From: [Adam Osbekoff](#)
To: [Chace Pedersen](#)
Subject: RE: CU-24-00003 Schnebly Coulee Solar Farm - Re-Notice of Application
Date: Tuesday, August 6, 2024 2:45:59 PM

Project Name Schnebly Coulee Solar Farm

Case Number CU-24-00003

TO: All Staff
FROM: Public Works Plan Review Team
DATE: June 12, 2024
SUBJECT: CU-24-00003 Schnebly Coulee Solar Farm-Updated

Figure 7.1. Conservation easements adjacent to, and within, the Project Area at the Schneibly Coulee Solar Energy Project, Kittitas County, Washington.

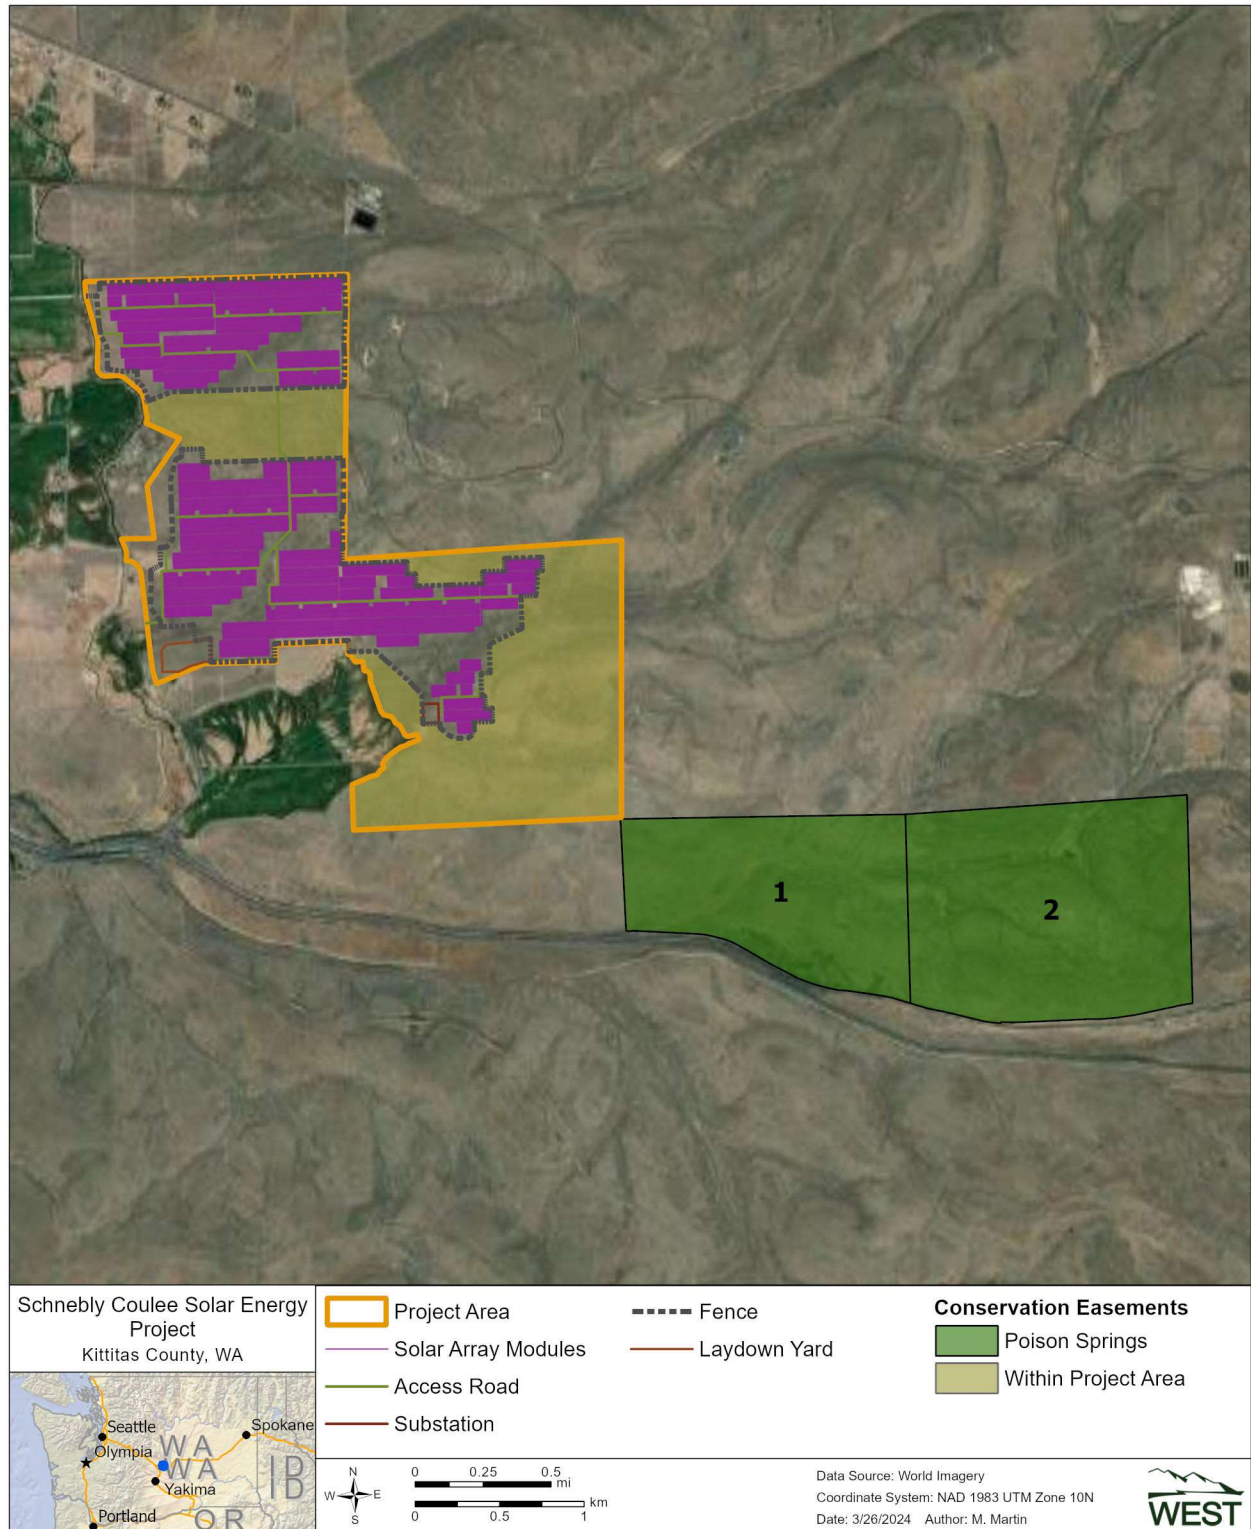
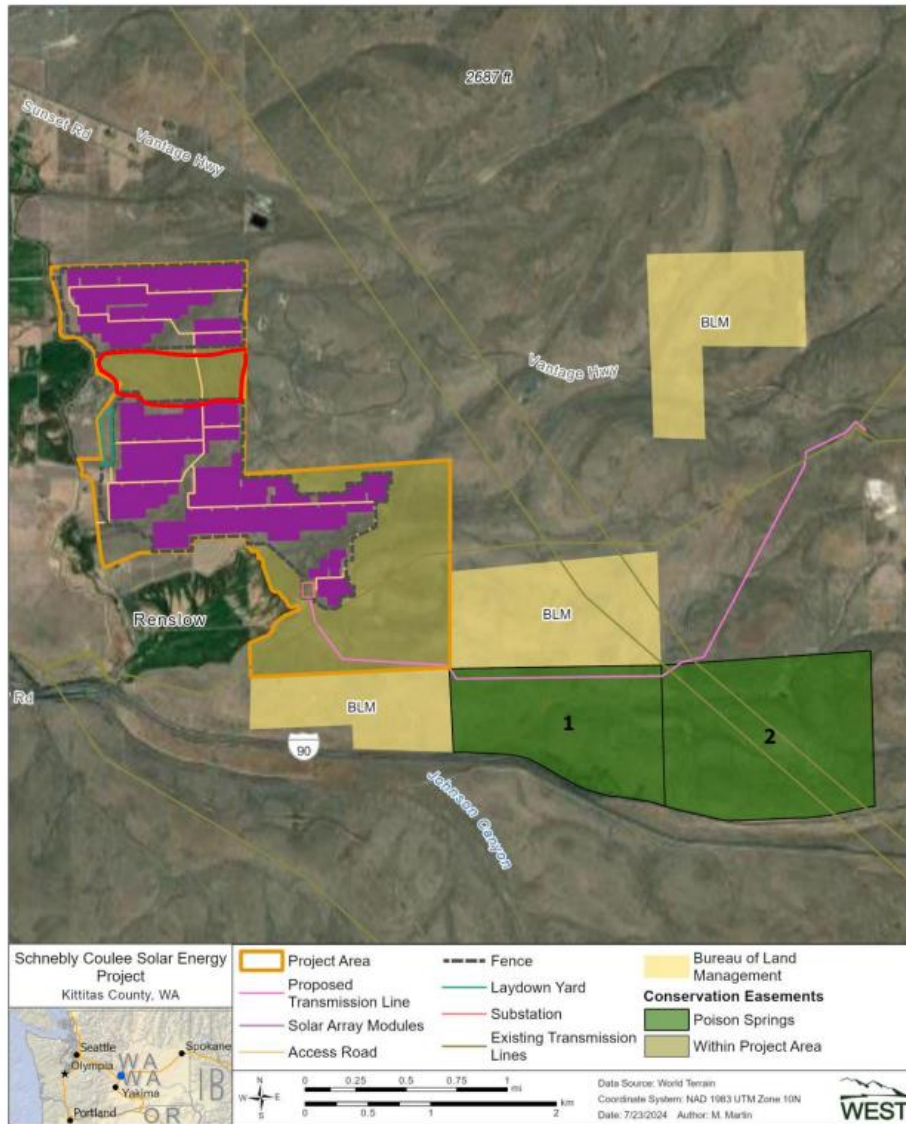
Schnebly Coulee Solar Energy LLC (applicant) has continued coordination with WDFW regarding the updated Habitat Management Plan, which includes mitigation ratios and other mitigation ratios that take all aspects of the project into consideration, including the recent addition of specific transmission line details.

View WNW from 2280 Sage Drive residence through viewing window

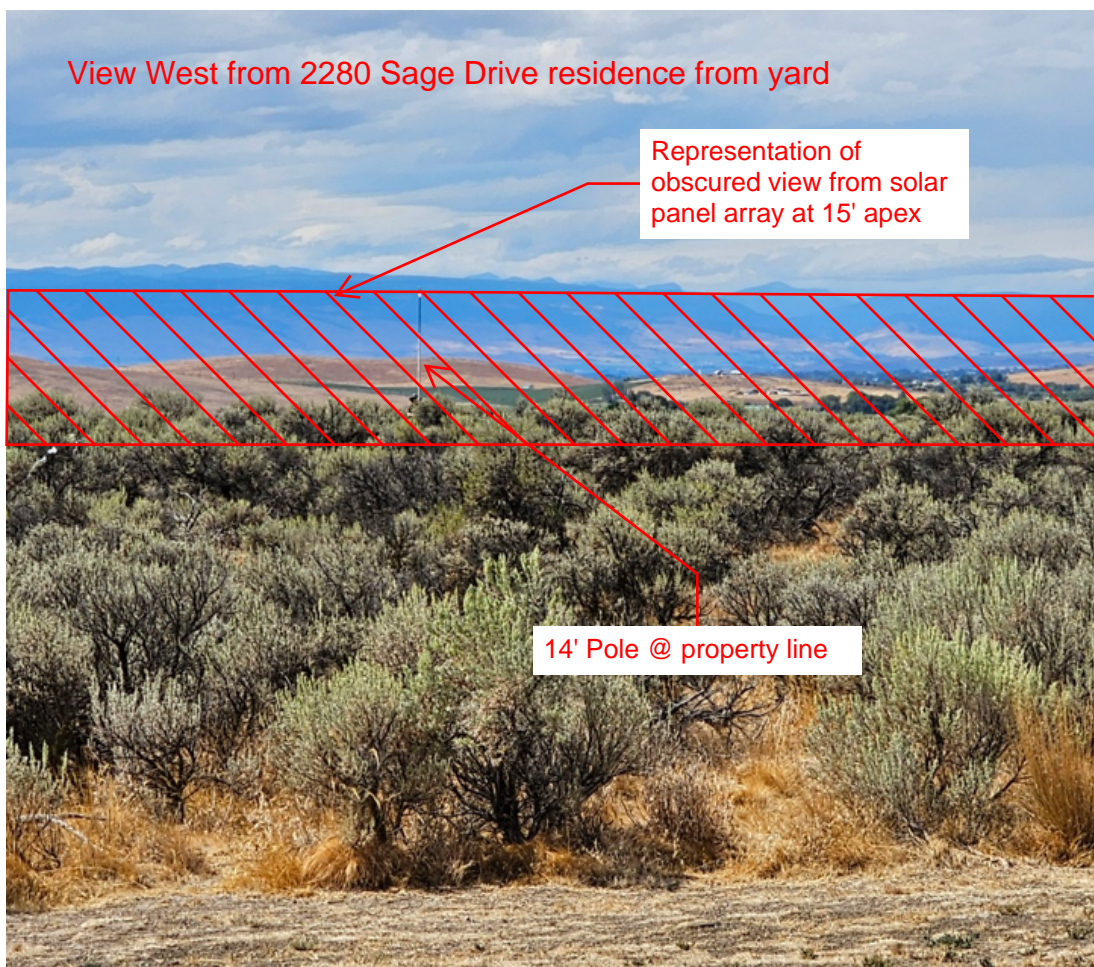
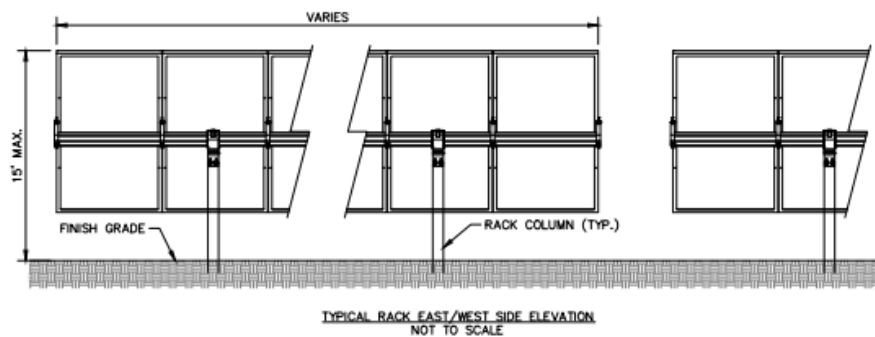
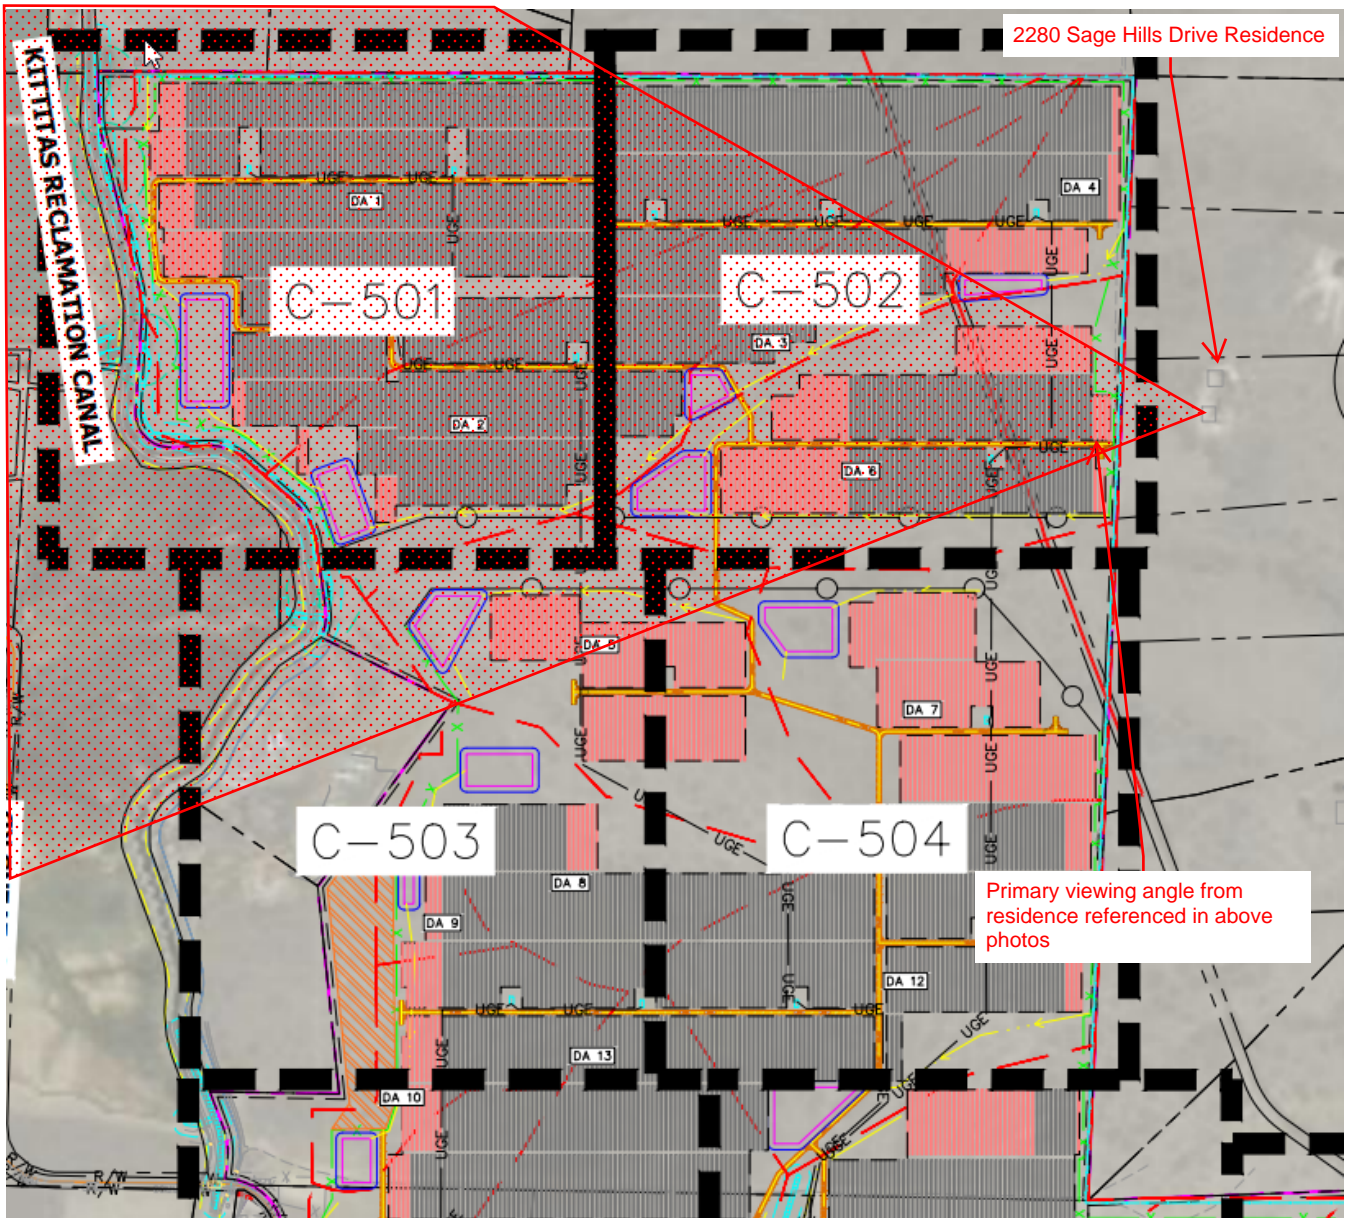
Utilizing a 14' pole to represent the approximate 15' apex of the solar array, we walked our property line along its western edge that abuts the C-502 section of the proposed solar project. As the property line was walked, we took photos from both the yard and the living room viewing windows from a standing position. The outcome as represented in the attached sketch indicates a significant reduction of the Western Kittitas County valley and surrounding scenery for which this property was chosen, and its residence design and construction was oriented around.

The impacted Westerly view from and the presence of the industrial installation will have deleterious effects to the value of the property, its future marketability and its current appreciation and enjoyment for which it was sought after and designed for.
